**KIRKLEES METROPOLITAN COUNCIL
INVESTMENT & REGENERATION SERVICE**

**DELEGATED DECISION FOR APPLICATION FOR CERTIFICATE OF
LAWFUL DEVELOPMENT**

Reference no.: 2025/CL/91730/W

Site: 4, Deighton Road, Deighton, Huddersfield, HD2
1UF

Plans, Sections & Elevations - As Proposed

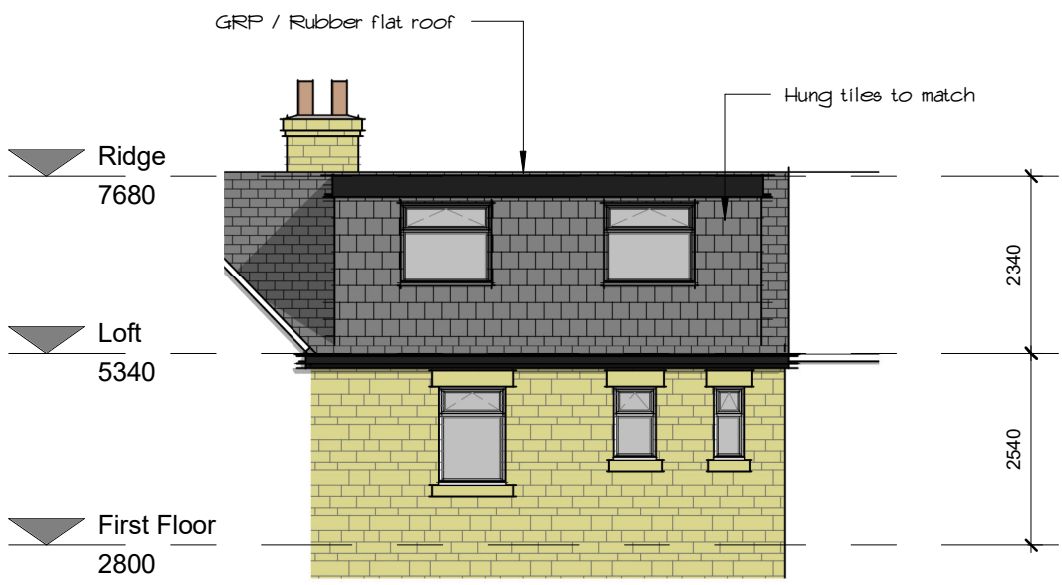
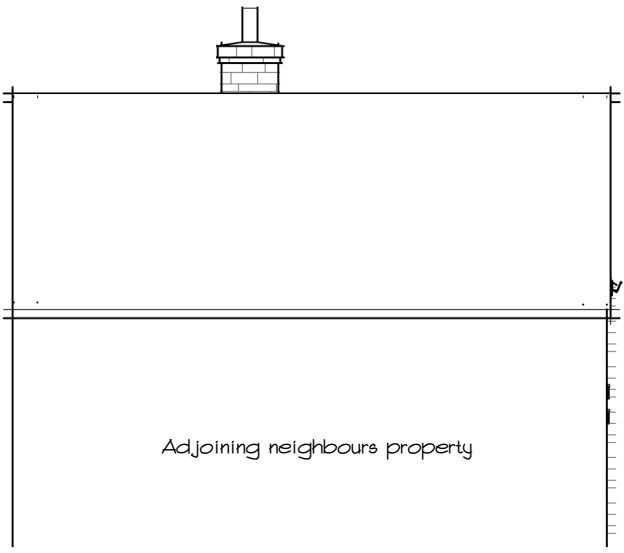
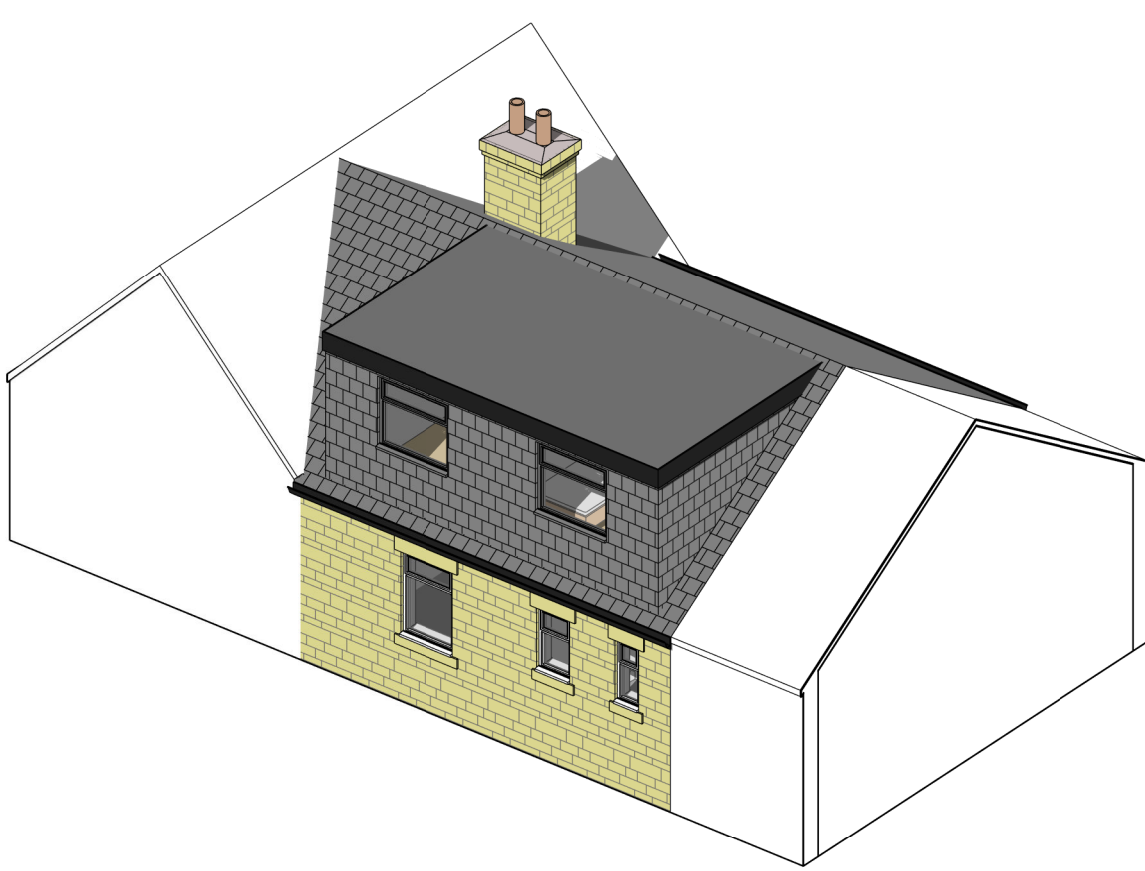
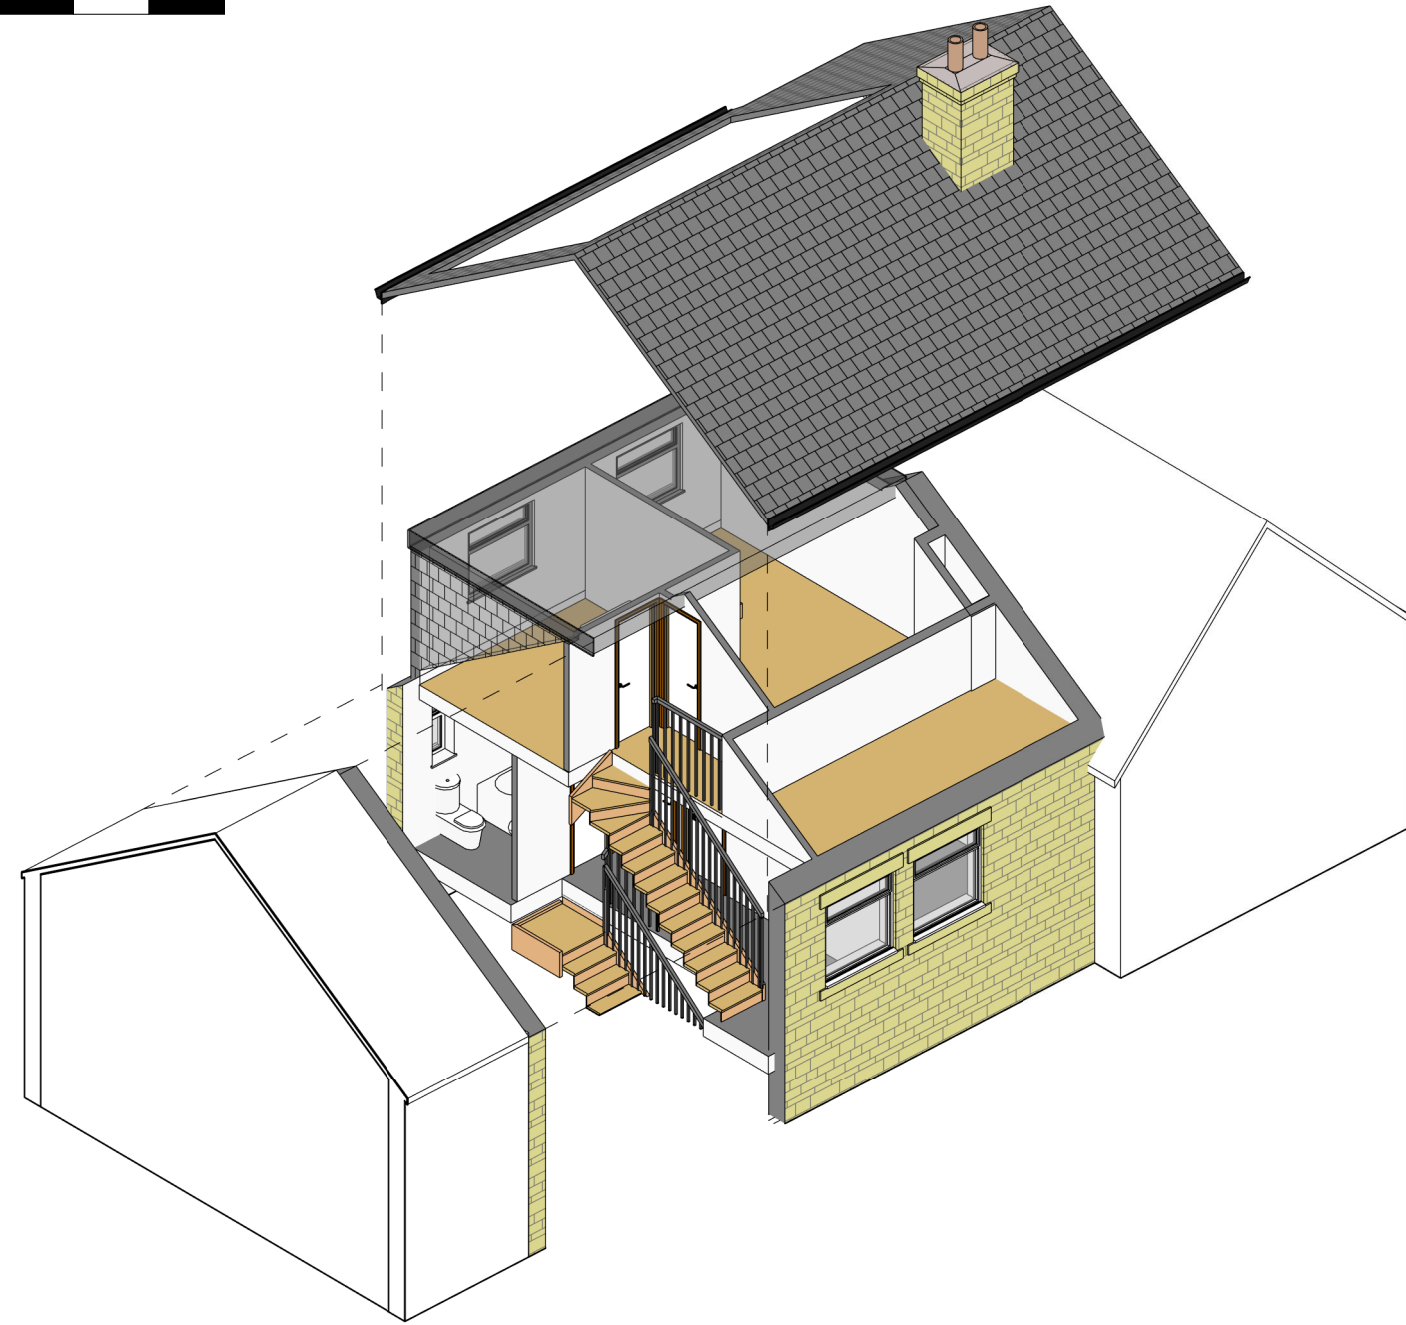
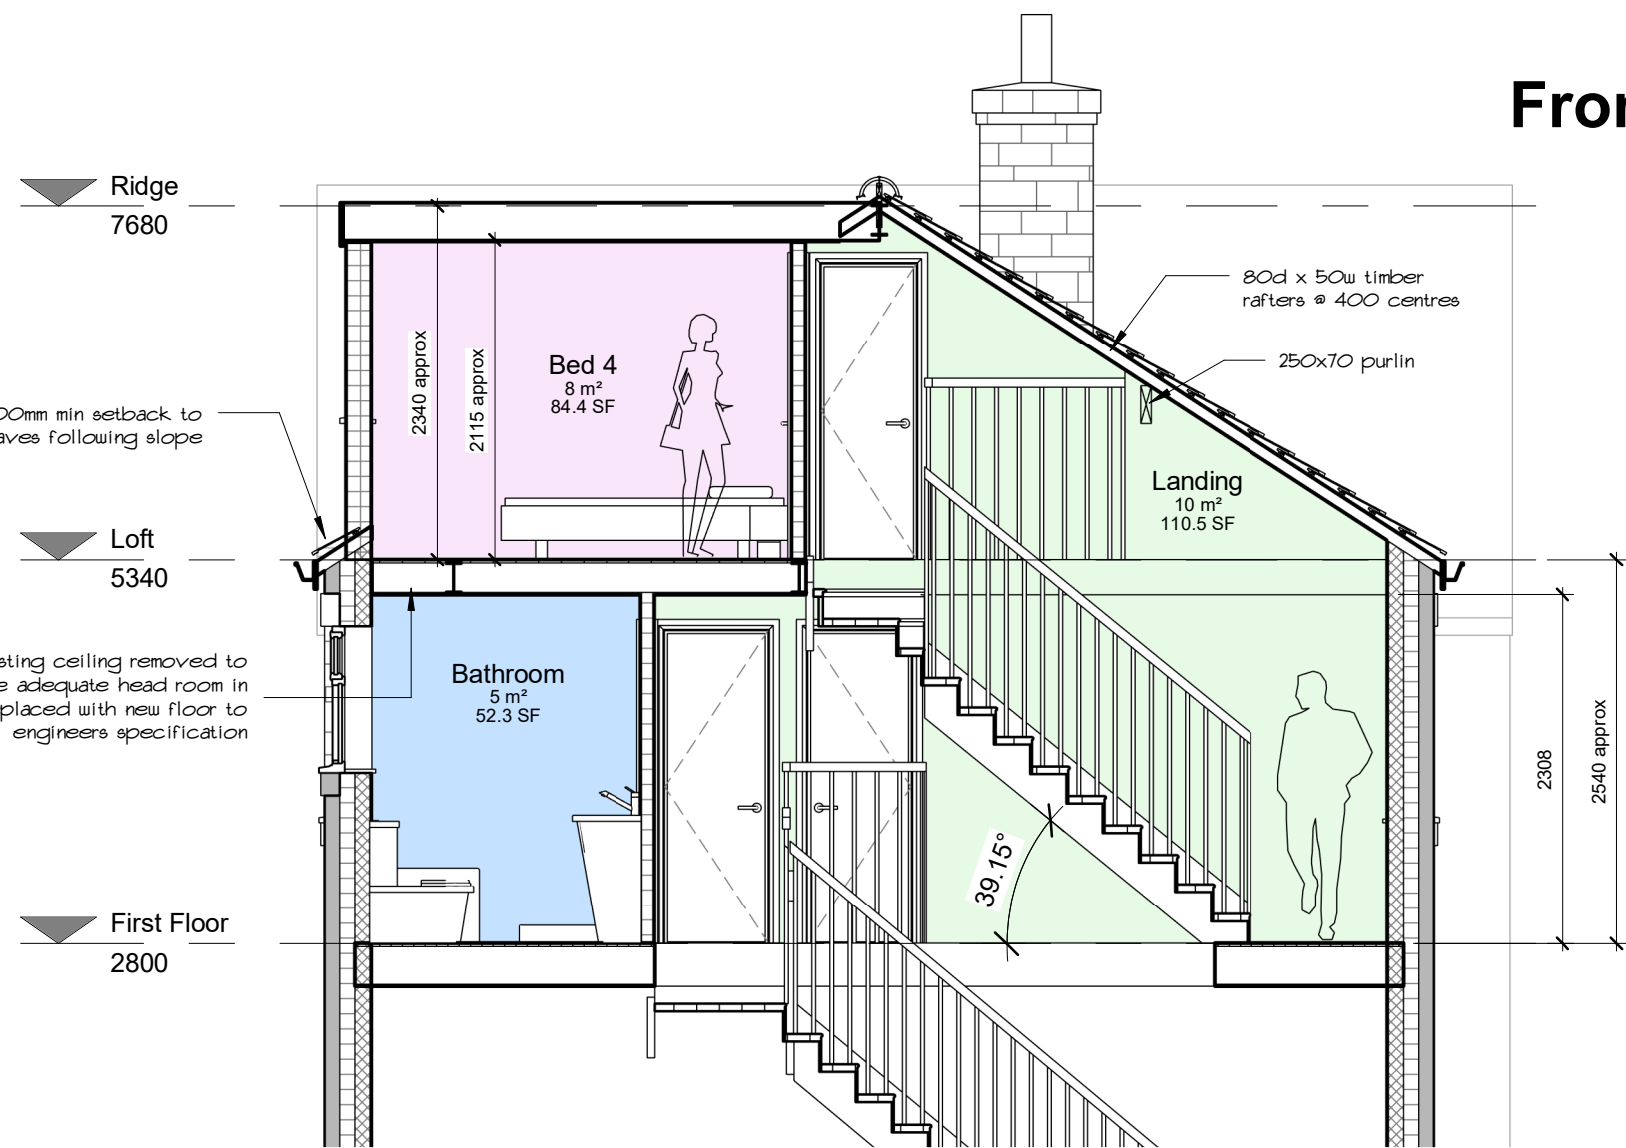
A dormer is proposed on the rear (north) facing elevation, set back from the existing eaves by approximately 0.2m running across most of the roof scape of the house at a width of 5.6 metres. The dormer would project 3.5 metres from the roof ridge and would be a total height of 2.4 metres. No part of the roof extension would exceed the highest part of the existing roof. The total cubic volume increase would be approximately 23.52 m³, which accords with the details annotated on the submitted plans.

The dormer would have 2 north facing windows and is proposed to be finished in hung tiles to match the existing for the dormer face and cheeks with the roof of the dormer finished with a GRP or rubber flat roof.

Comment: *No part of the dwellinghouse would exceed the height of the highest part of the existing roof.*

Comment: *No part of the dwellinghouse would, as a result of the works, extend beyond an existing roof slope which forms the principal elevation.*

Comment: *The cubic content of the resulting roof space would not exceed 40 cubic metres. The proposed additional volume is within this limit.*
